Planning Inspectorate

Our Ref: EN010162

Application by Elements Green Trent Limited for an order granting development consent for the Great North Road Solar and Biodiversity Park

Advice following issue of decision to accept the application for examination

Drawing Title:
Statutory and Non-Statutory Features of Historic Environment Plan
SHEET 5 of 39

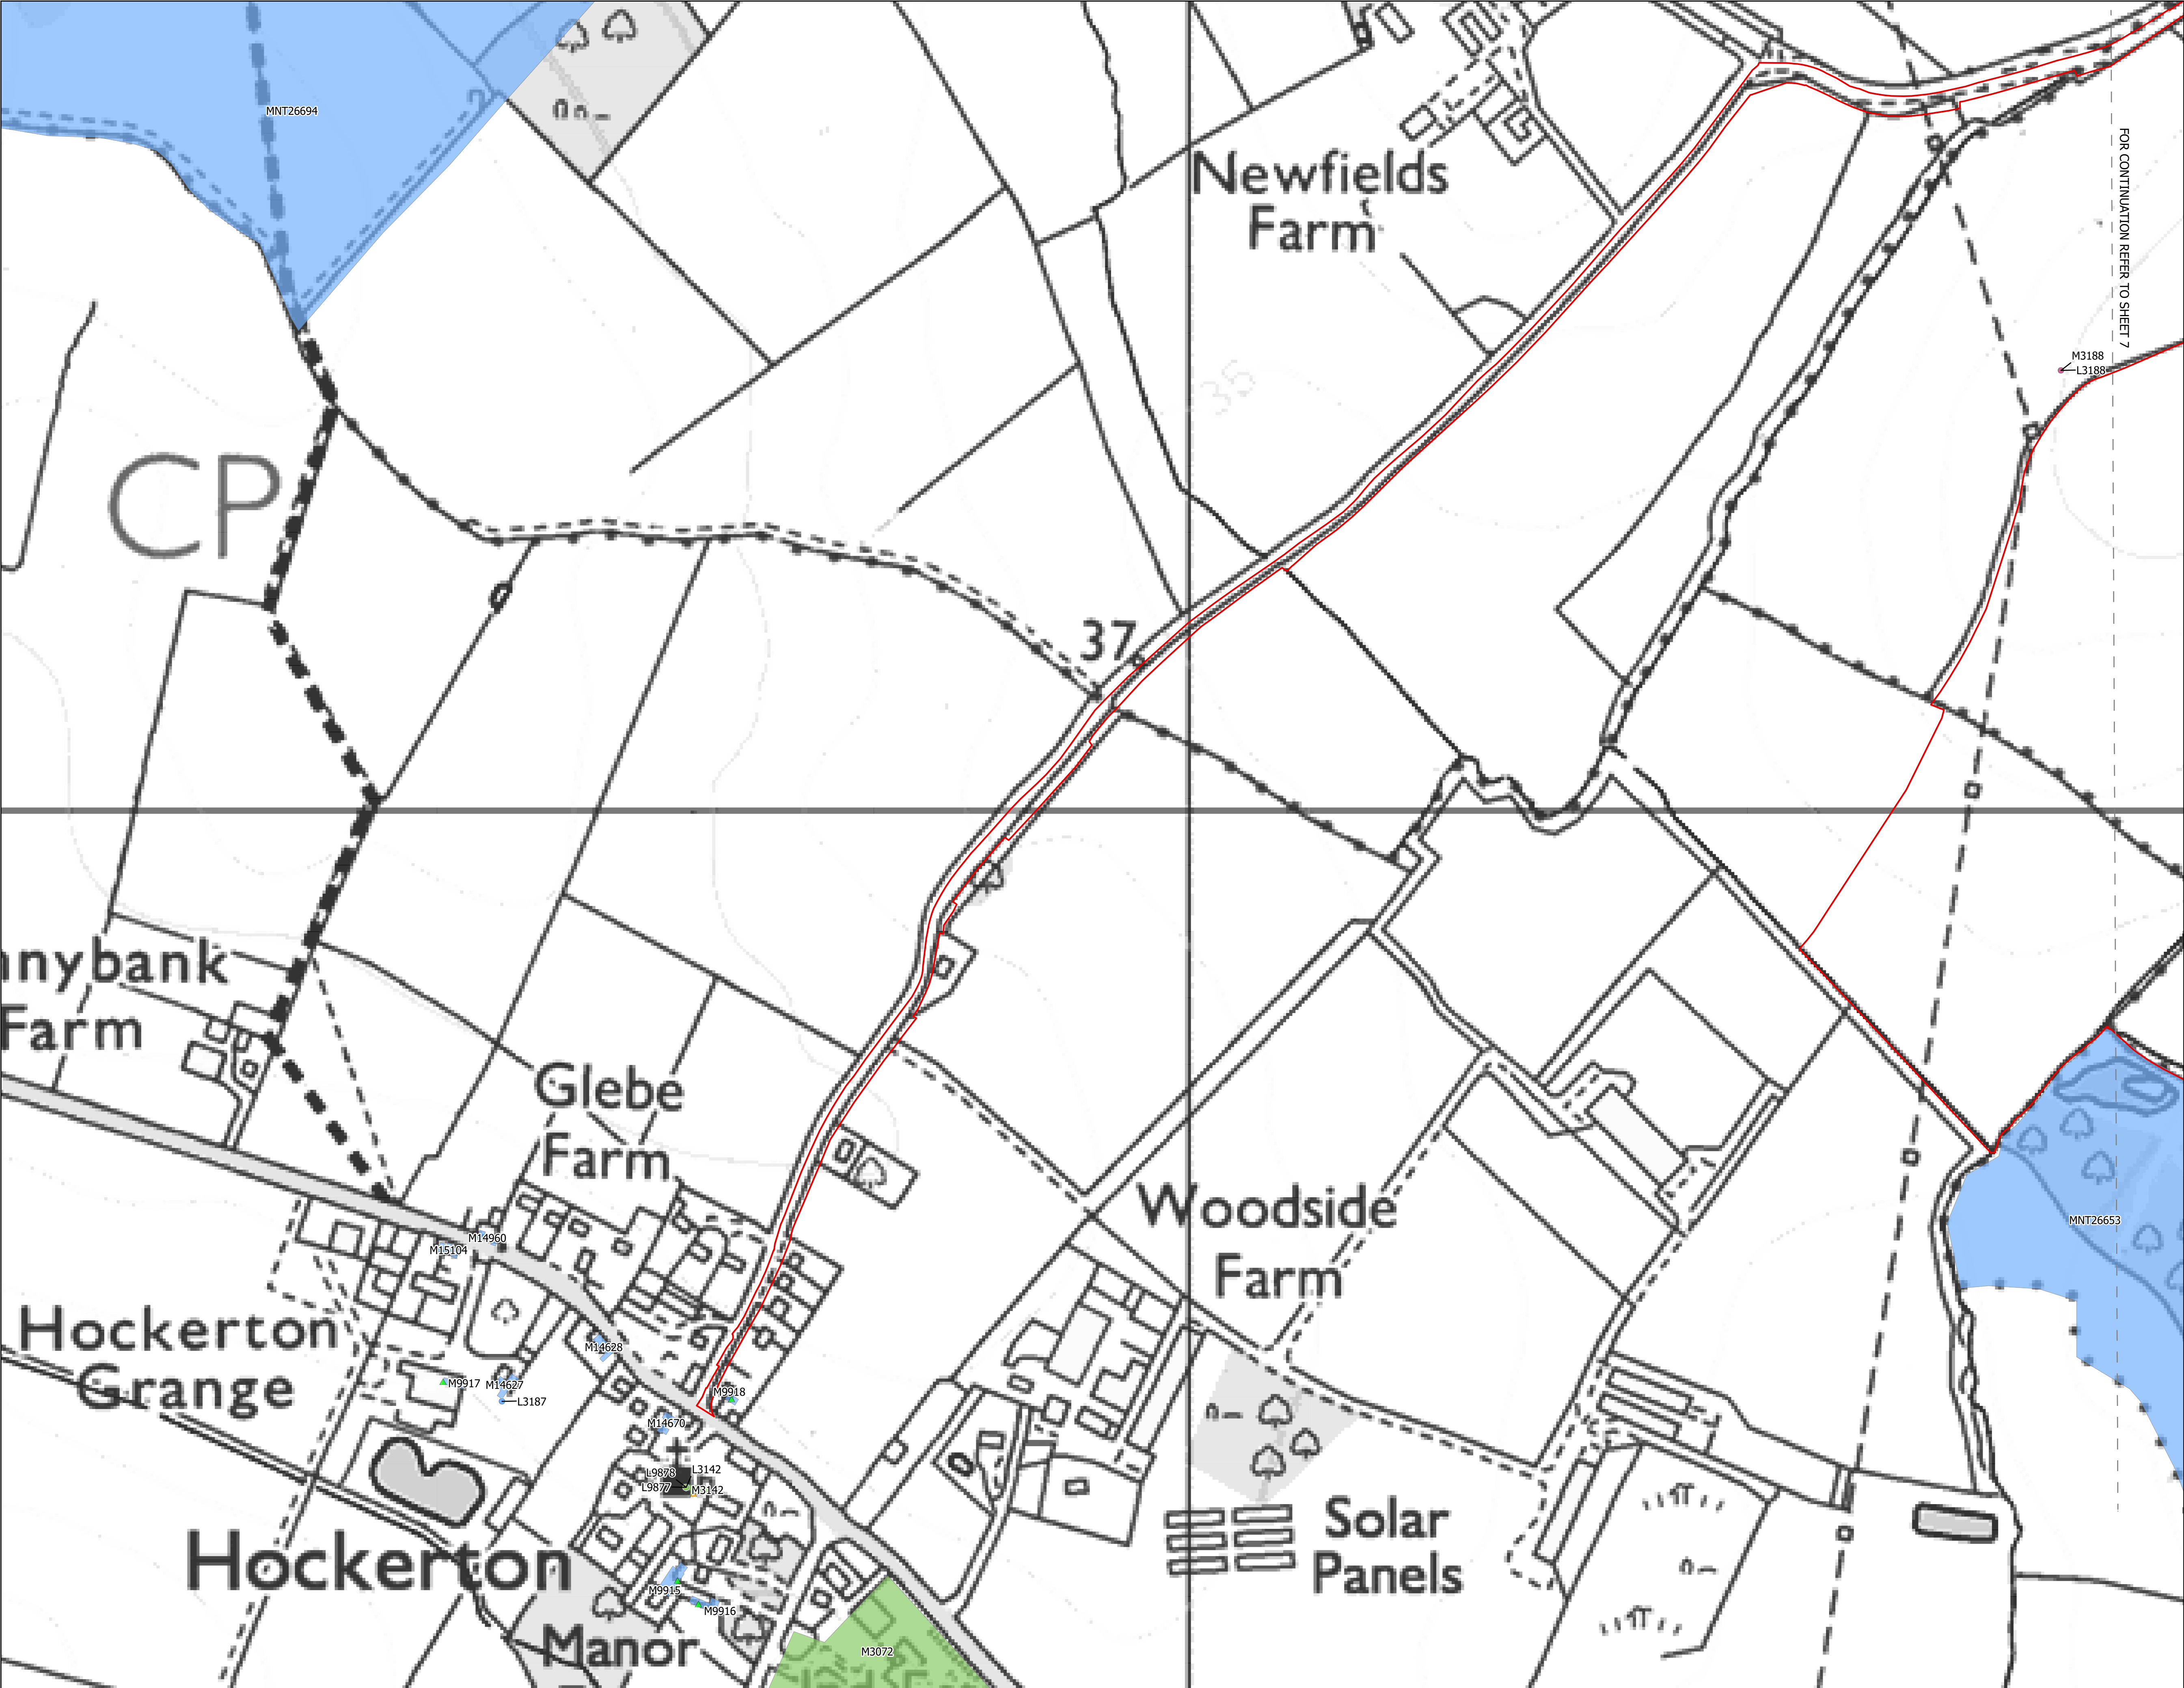
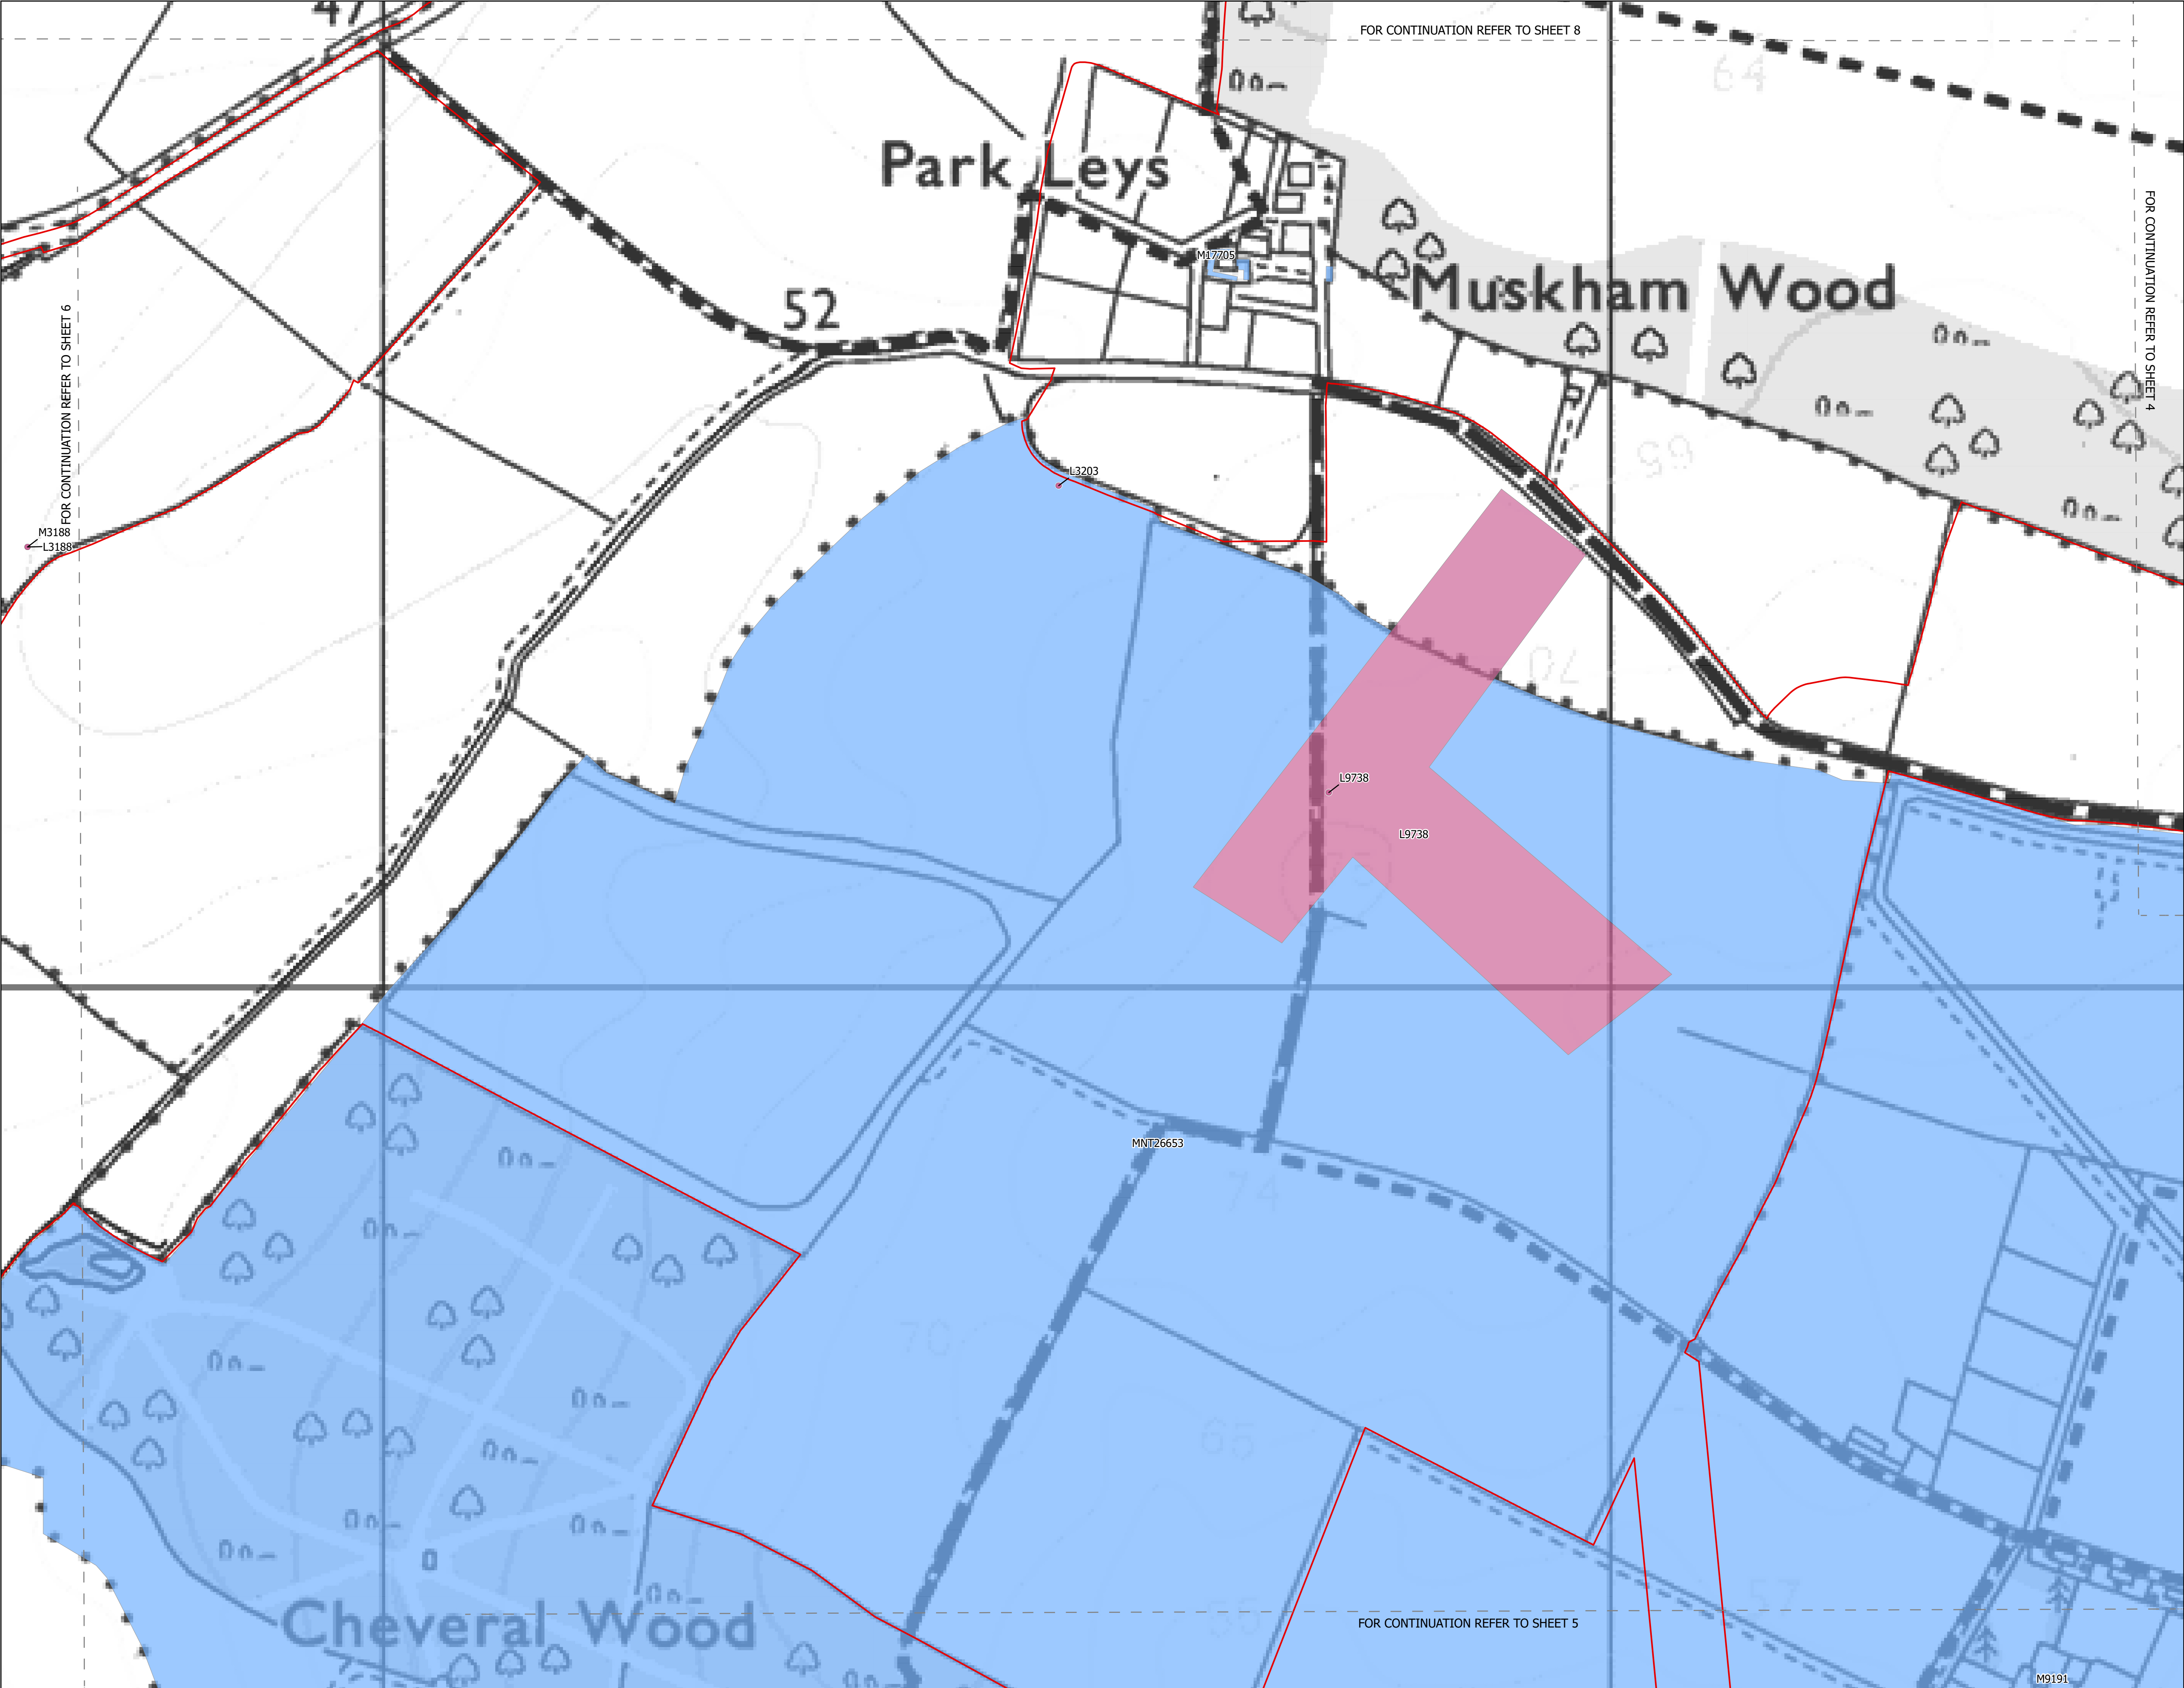
Statutory and non-statutory features of Historic Environment Plan (Doc 2.17)

The applicant is advised to review these figures for clarity, specifically relating to the following points:

- due to the scale of the icons used and similar colouring, it is difficult to differentiate between Historic Environment Record (HER) assets and listed buildings/ grades
- a very similar colouring scheme between HER recorded 'undated' period and scheduled monuments keys has been used
- due to the small scale of the icons, the labelling sometimes obscures the record being shown.
